From: Simon Davis
Sent: 17 December 2021 15:57
To: 'Tilly Whishaw' [REDACTED]
Cc: Craige Burden [REDACTED] Isabelle Renn [REDACTED]
Subject: FW: Planning Consultation on: Y/163/21/DOC Land at Street Buildings

Please see below comments from Roger Spencer re the drainage condition.

Looking at the wording of the Condition, it does indeed read as the Condition for the Ford Lane scheme; in that it requires details of the implementation, maintenance and management of a sustainable drainage scheme, omitting the need for a number of details requested previously in relation to the design of the drainage scheme; I am guided by the interpretation that was put upon the Ford Lane scheme and would limit my comments accordingly.

Proposed Drainage Design Layout Sheets

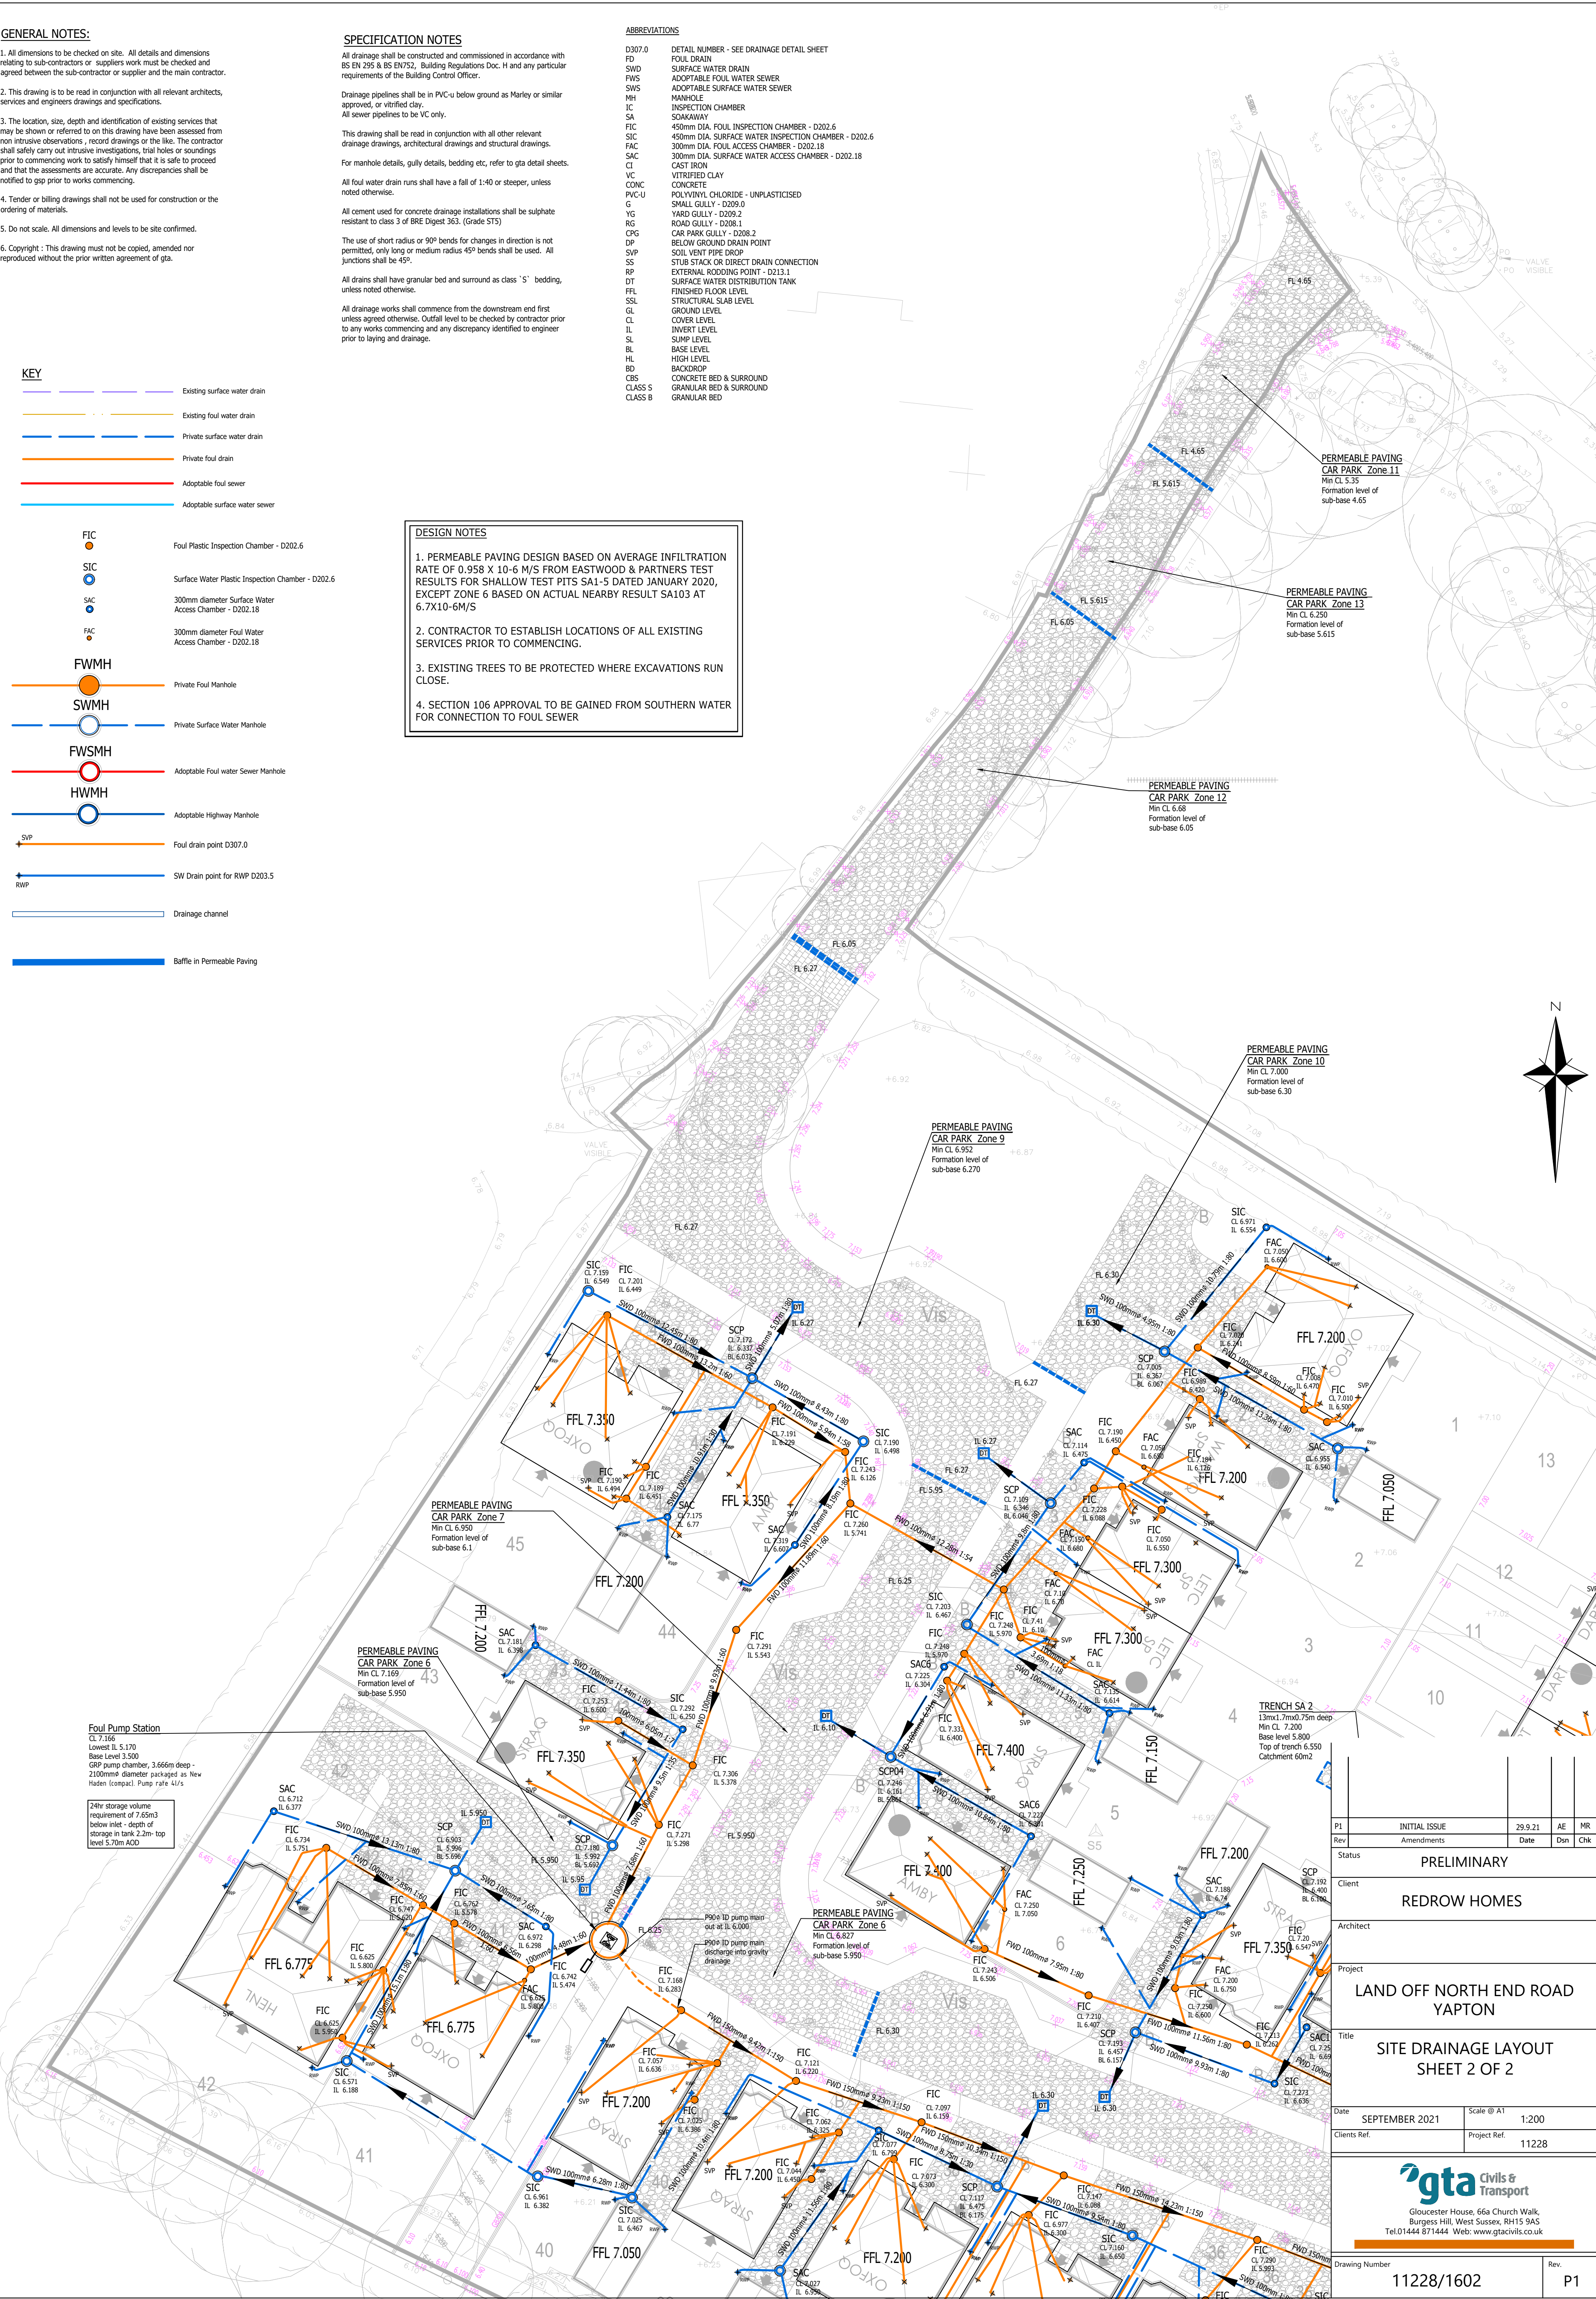
The drainage layout is included in the Foul & SuDS Drainage Statement & Maintenance Plan but I note that a previous comment relating to an infiltration blanket for Zone 9 is not addressed. I would also suggest that the document contains a lot of information that is not relevant to ongoing maintenance; it would therefore benefit from the content relating to maintenance and management being separated out into a standalone document – with relevant information (plans & drawings etc.) pulled into it. As it stands, there is scant information in the whole document for those undertaking the future maintenance knowing what is required. More details and descriptions of the various elements/components of the system should be included e.g. cross sections, depths, dimensions, etc. and images of what things should look like (the Ford Lane manual is better in this respect).
